RE: Food Lion #2594
3260 Ray Road
Spring Lake, NC 28390

This letter acknowledges review of the remodel plan for the above referenced establishment. The plans received on 09/14/2023 and specifications including email correspondence are approved with the following conditions and comments:

**7 SUSPENDED BOAT RACK AT LAY-IN CEILING**  
A3.01 Scale 1/2"=1'-0"

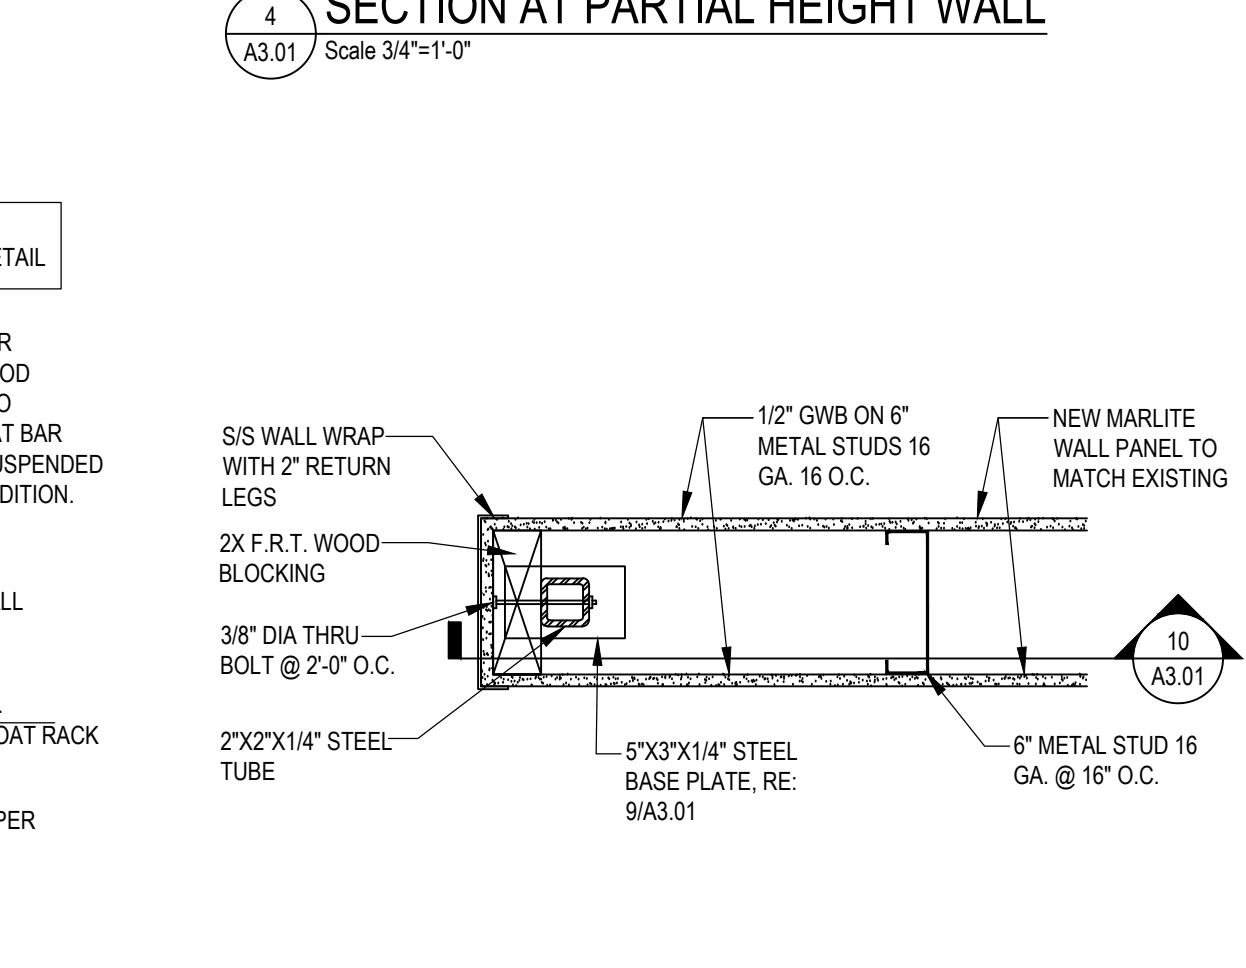
1. The scope of work covers the addition of new and relocated equipment in the Deli/Bakery Prep/Sales Areas. The installation of new equipment on the scope and revised equipment plan, included with this approval letter, were noted as follows: cold and hot deli cases, boat racks, stainless tables and a *combi-therm oven with grease cart.
